Application H12-0518-16
Location Adjacent: 2 School Lane Lutton Spalding PE12 9HW
Proposal Erect pair of 3 bedroomed semi-detached houses (re-submission of H12-0281-16)

Name Louise Jennings Historic Environment Officer
Address Historic Environment Officer Lincolnshire County Council Witham Park House LN5 7JN

Date Submitted 21-06-16
For/Against Comments

Drawing. FLOOR PLANS - ELEVATIONS
BLOCK & LOCATION PLAN

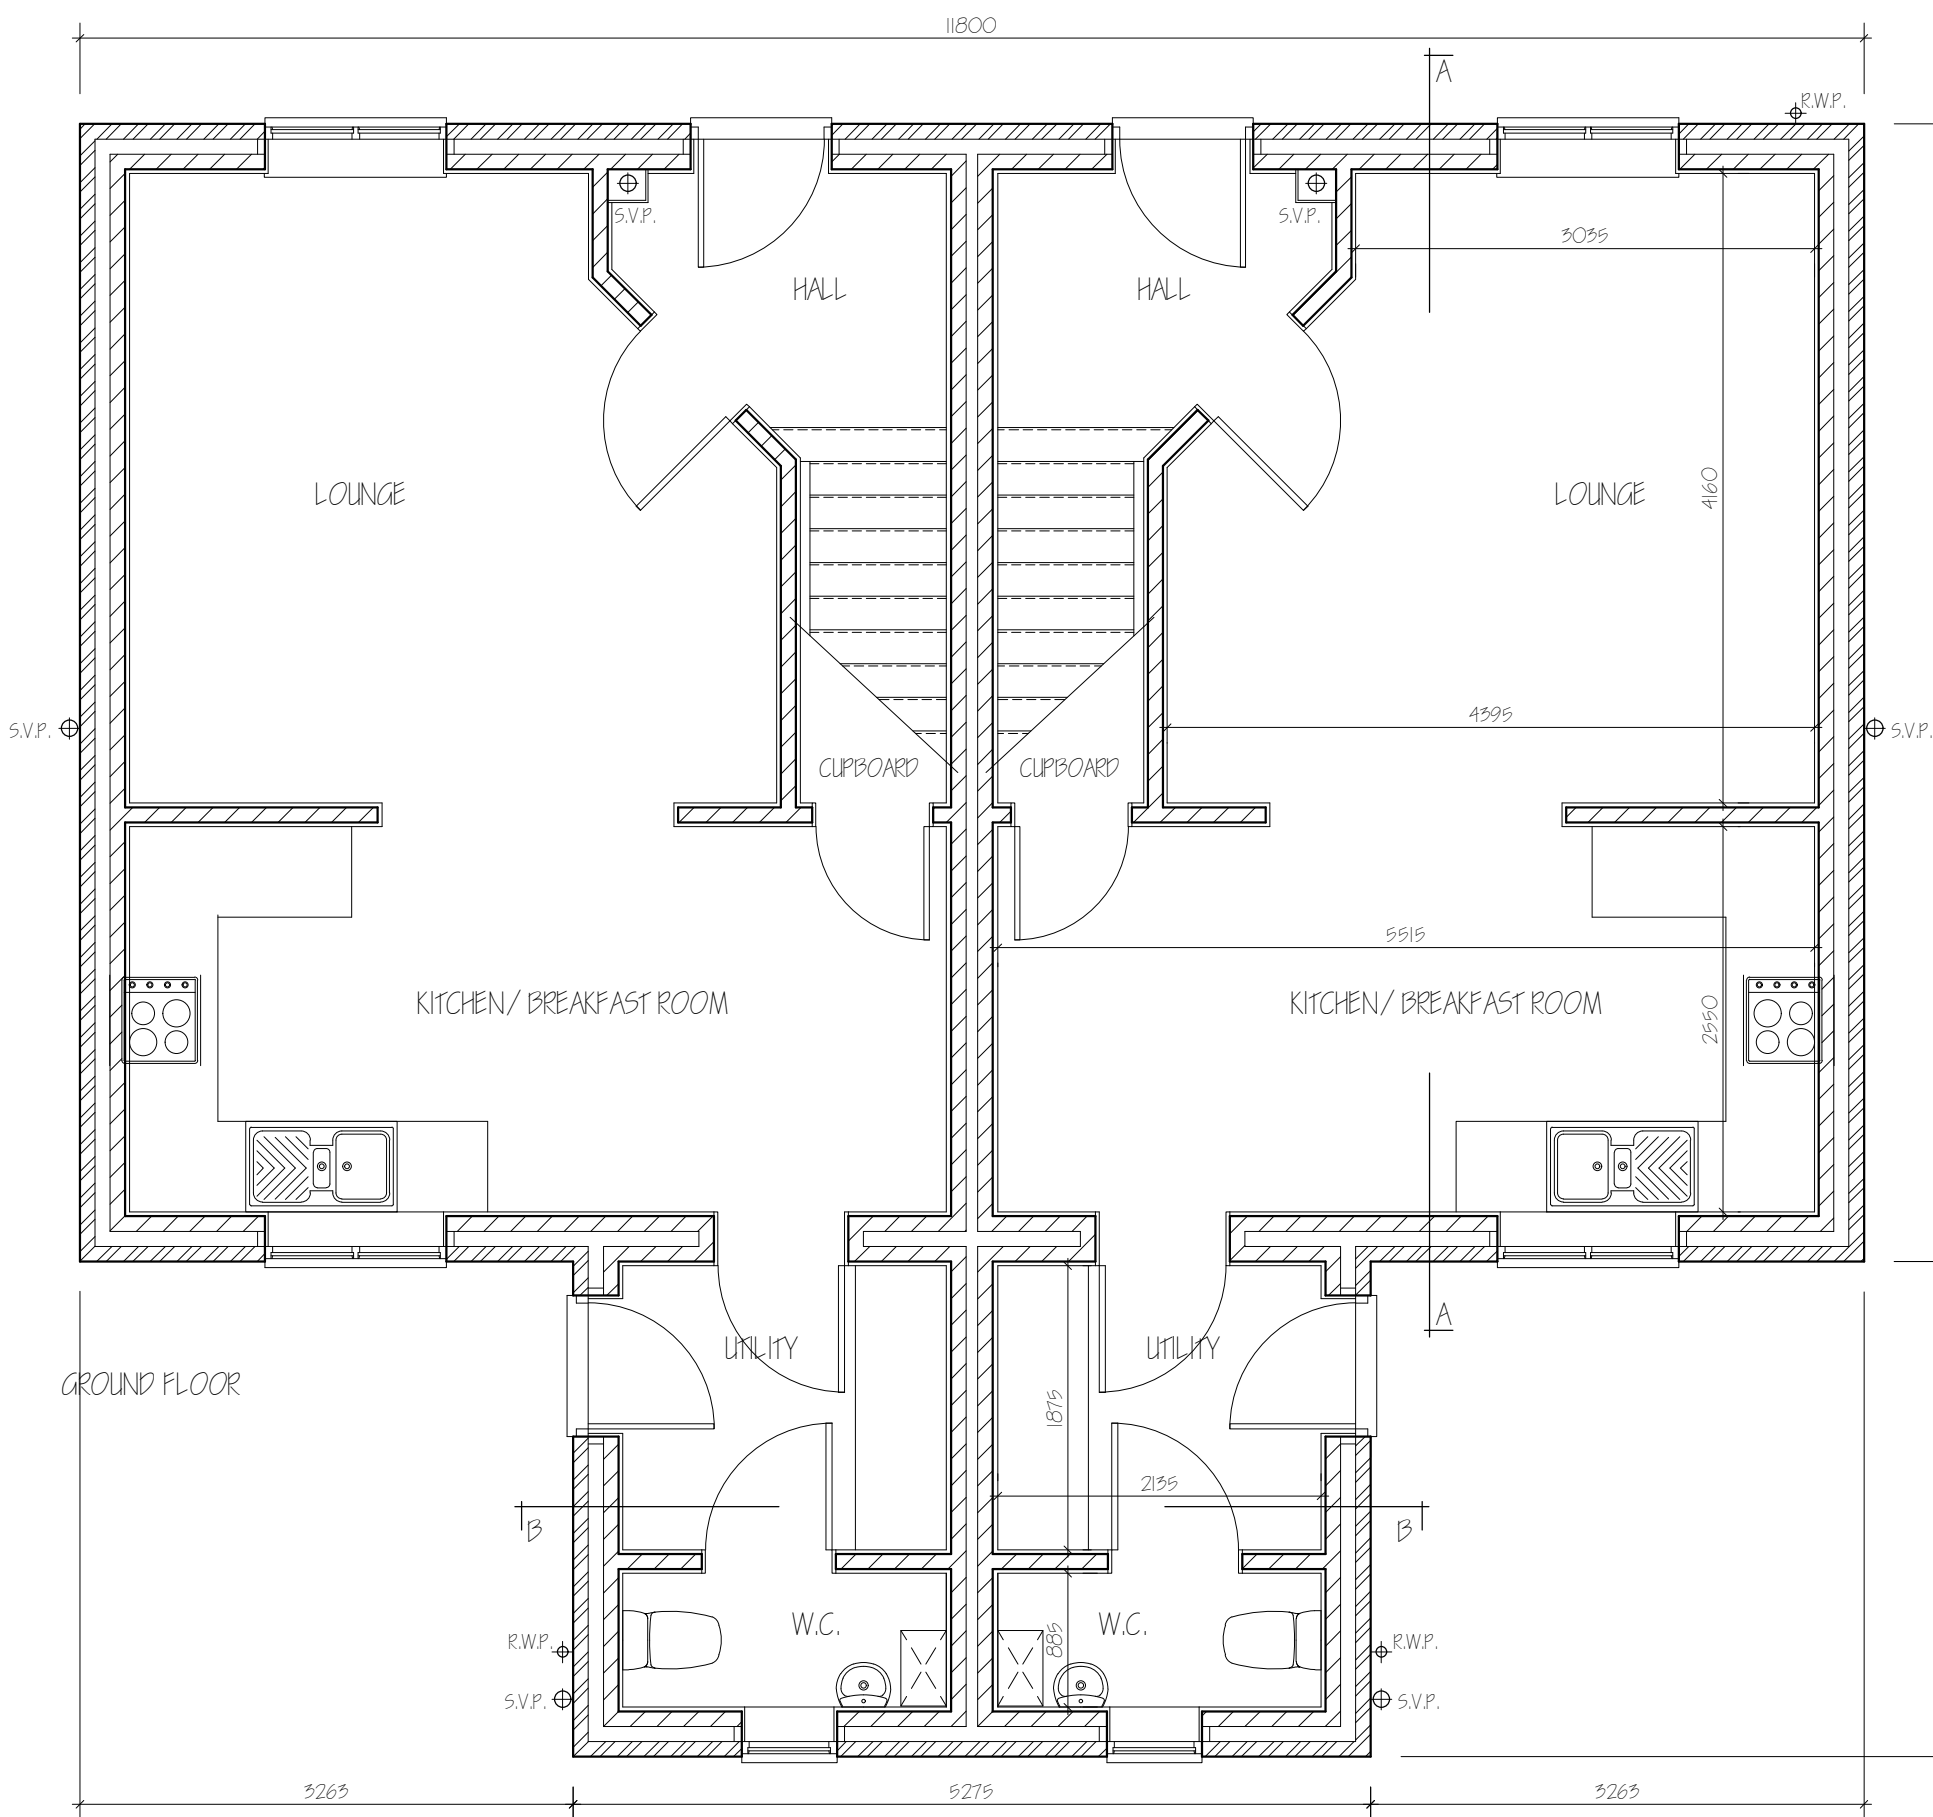
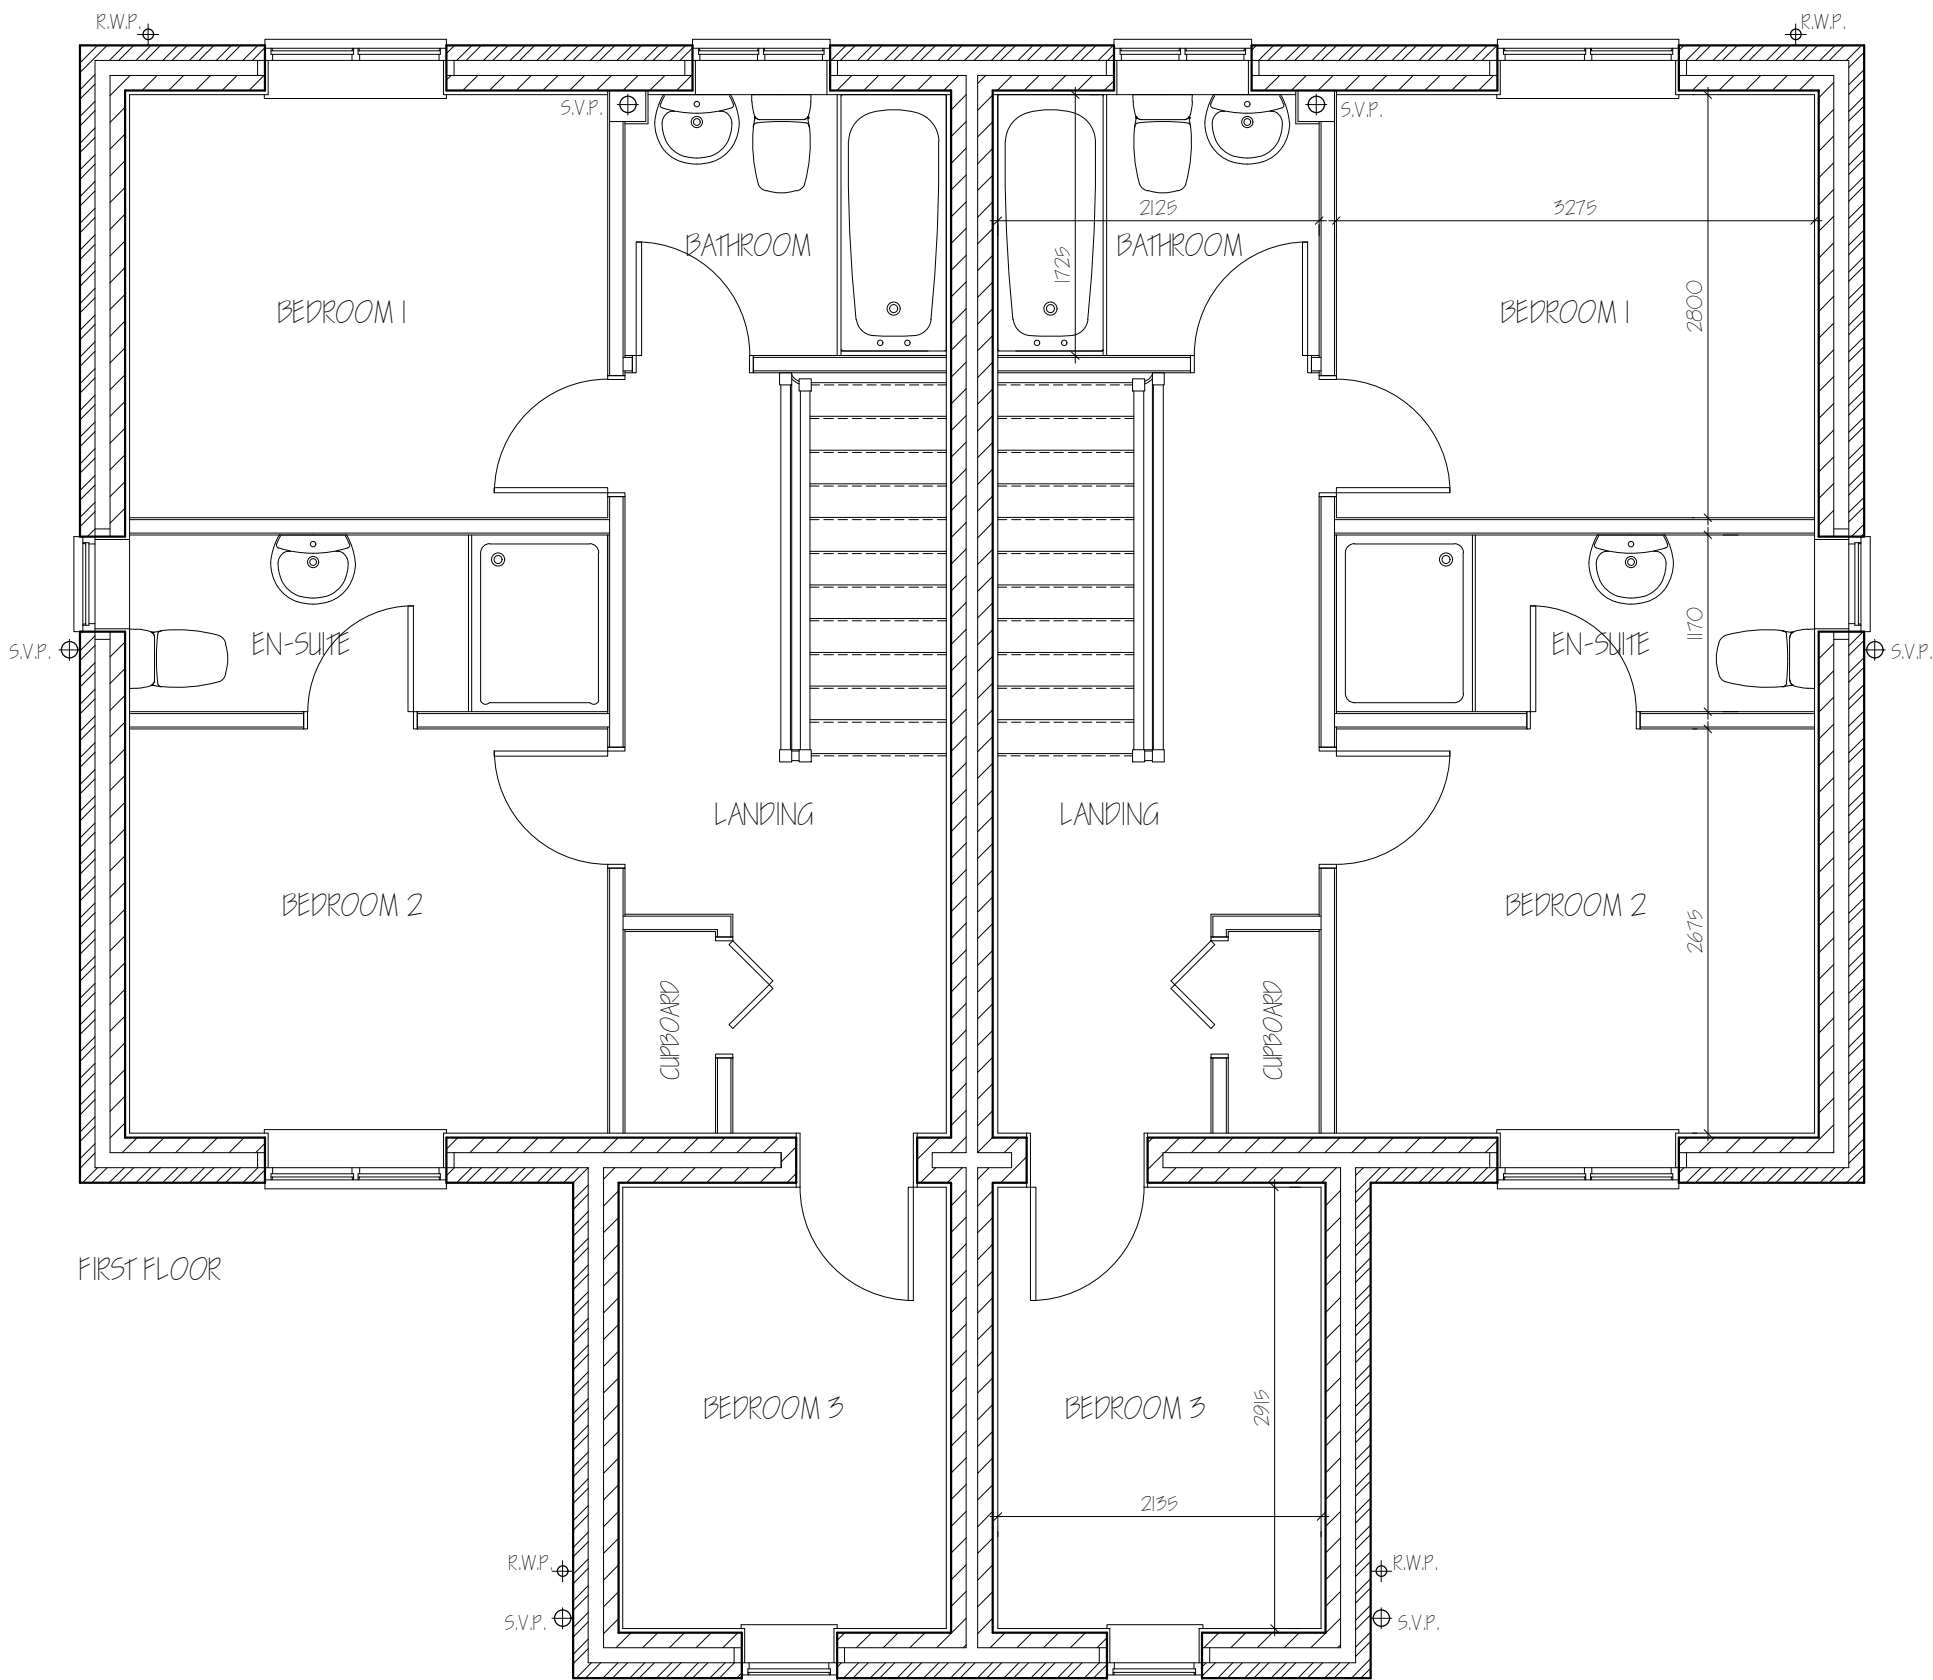
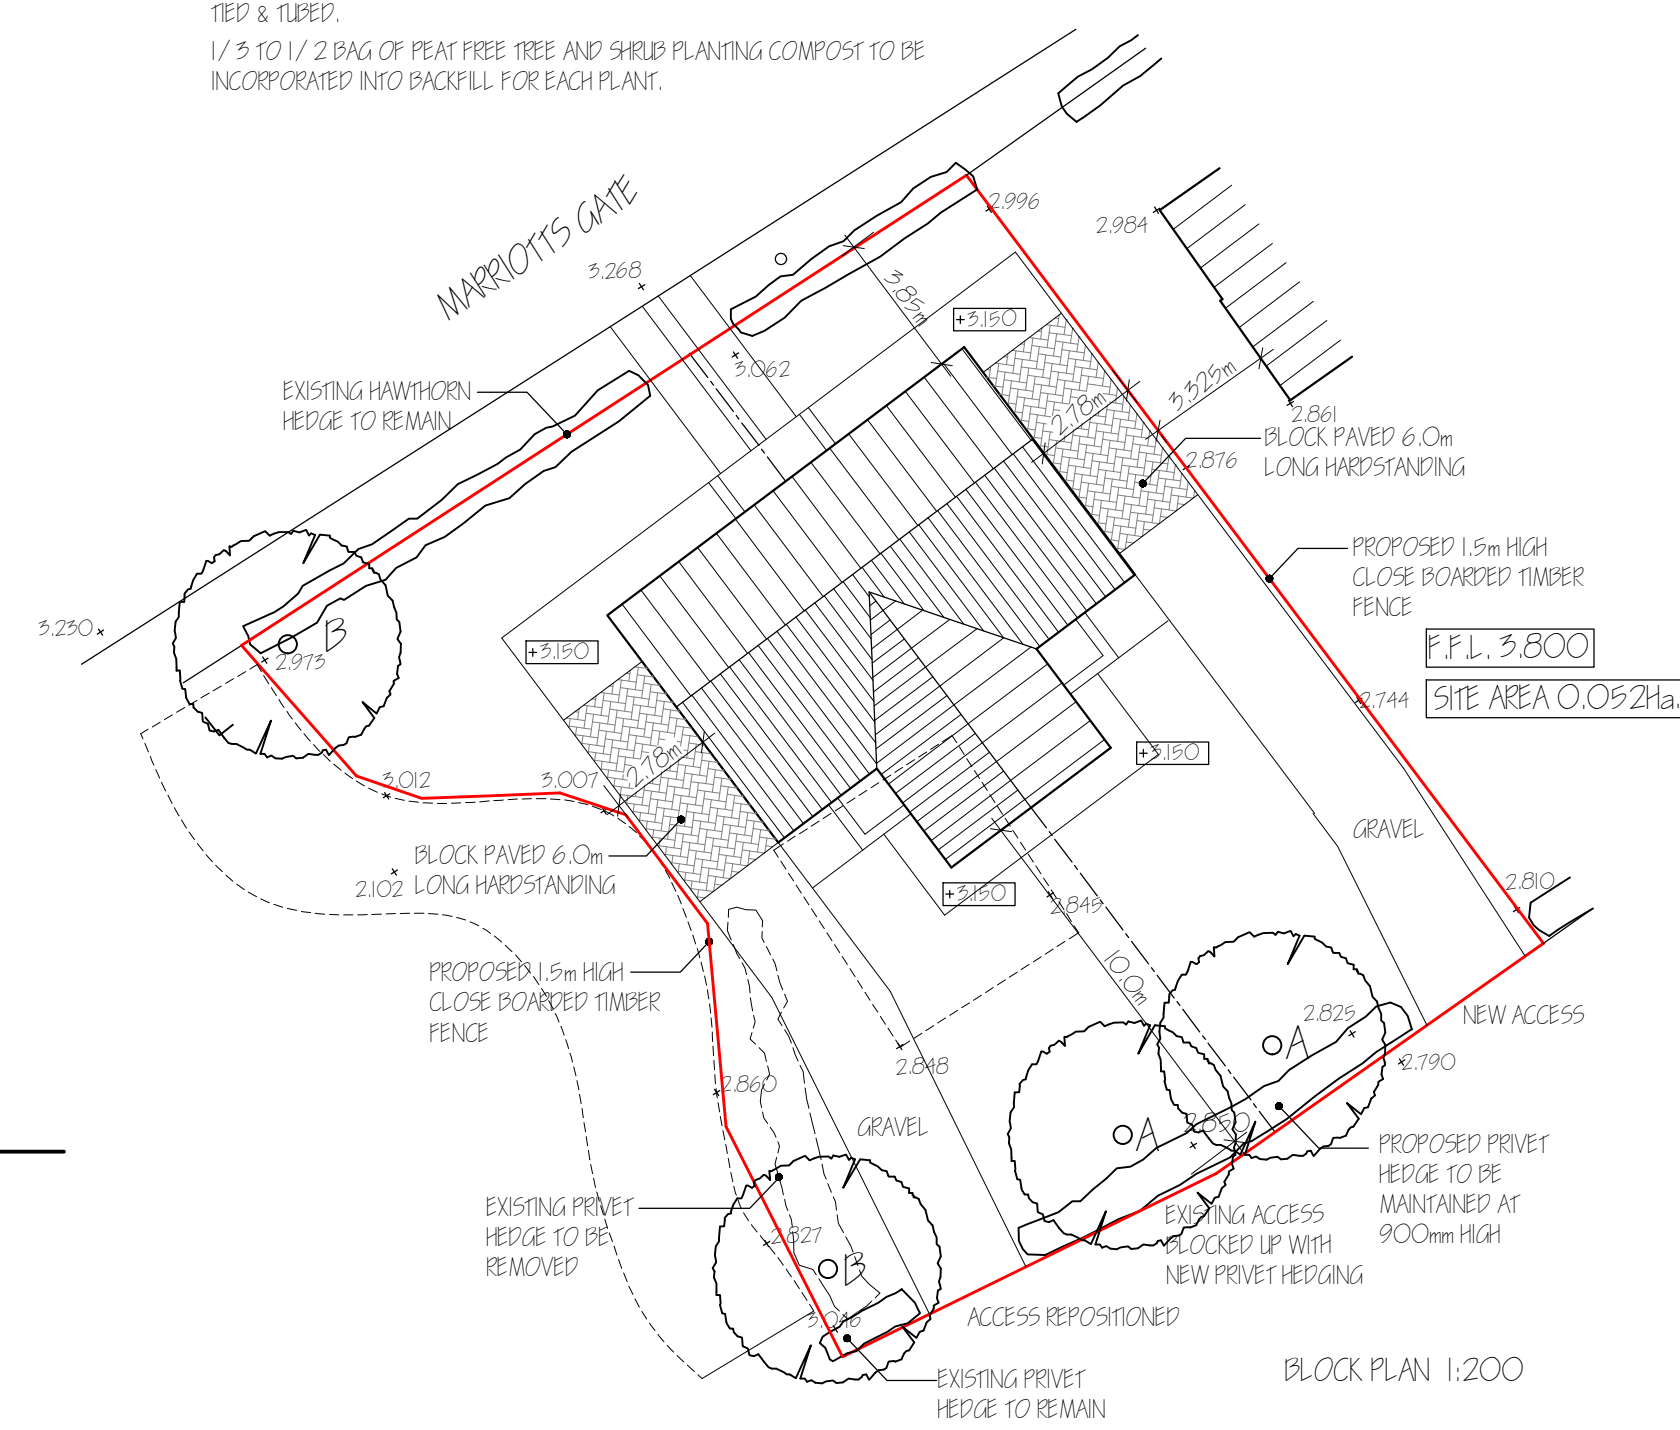
The cottage on this site is possibly eighteenth century and despite the extension of more recent date it is of historic interest. Parcelling off part of the garden and erecting two semi-detached modern houses will destroy the historic relationship between this Cottage and its original boundaries.

In addition to this, this site lies within the heart of Lutton, the land pattern suggests that this area was inhabited at least as early as the medieval period and possibly earlier. Any development of this site could disturb archaeological remains relating to this period.

Given this, I would recommend that the development be refused.

However if permission should be forthcoming I recommend that an archaeological scheme of works condition (4.8.1 in the archaeological handbook) is attached to any permission to enable archaeological remains within the site to be recorded prior to their destruction. Therefore given this it is recommended that the developer should be required to commission a Scheme of Archaeological Works (on the lines of 4.8.1 in the Lincolnshire Archaeological Handbook (2012)). This should be secured by South Holland District Councils Standard Conditions AR01, 02 and 03.

Initially I envisage that this would involve monitoring of all groundwork's, with the ability to stop and fully record archaeological features.
